Joyful View Subdivision
Traffic Impact Study
PCD File No.: SF22-31
(LSC #S214050)
June 30, 2023

LSC Responses to TIS
redline comments

LSC Responses to TIS Redline Comments

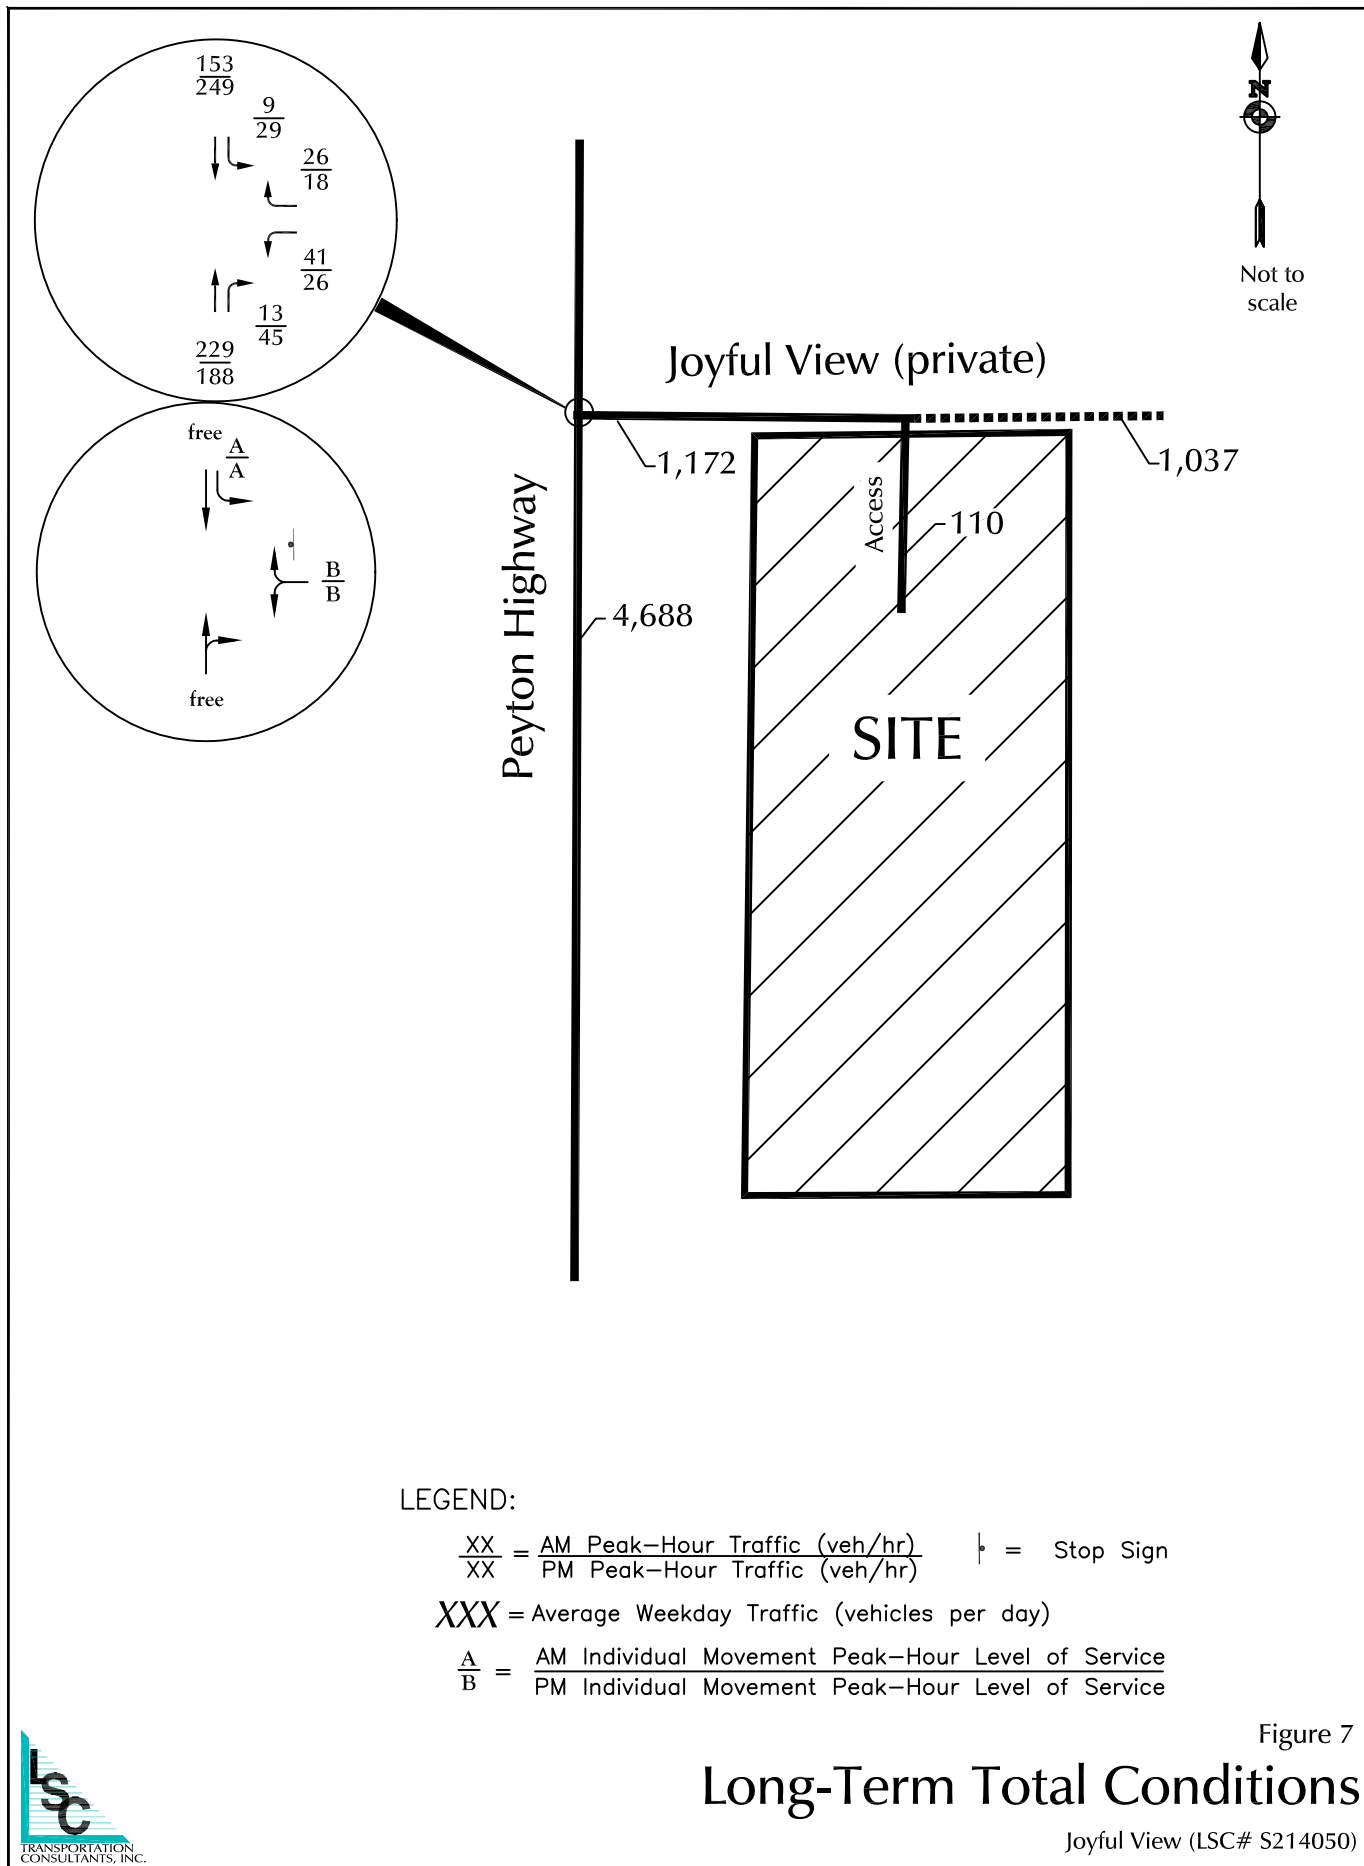
Log Road is over 1mi to the east beyond Jd Johnson. The parcels of Grand View Estates III/IV intended to have access to Peyton Road to west and Jd Johnson to east not to Log Road. Update the long term traffic volumes for Joyful View to reflect this. Current 2040 analysis only reflects two subdivided parcels worth of traffic not the remainder of the the parcels. Update FIG7

See previous comment
 2043 condition do not account for other parcels to east or planned access

LSC Response: The report has been revised to include estimates of future background traffic that could be generated with the development of parcels to the east along and north of Joyful View.

LSC Response: The report has been revised to include estimates of future background traffic that could be generated with the development of parcels to the east along and north of Joyful View.
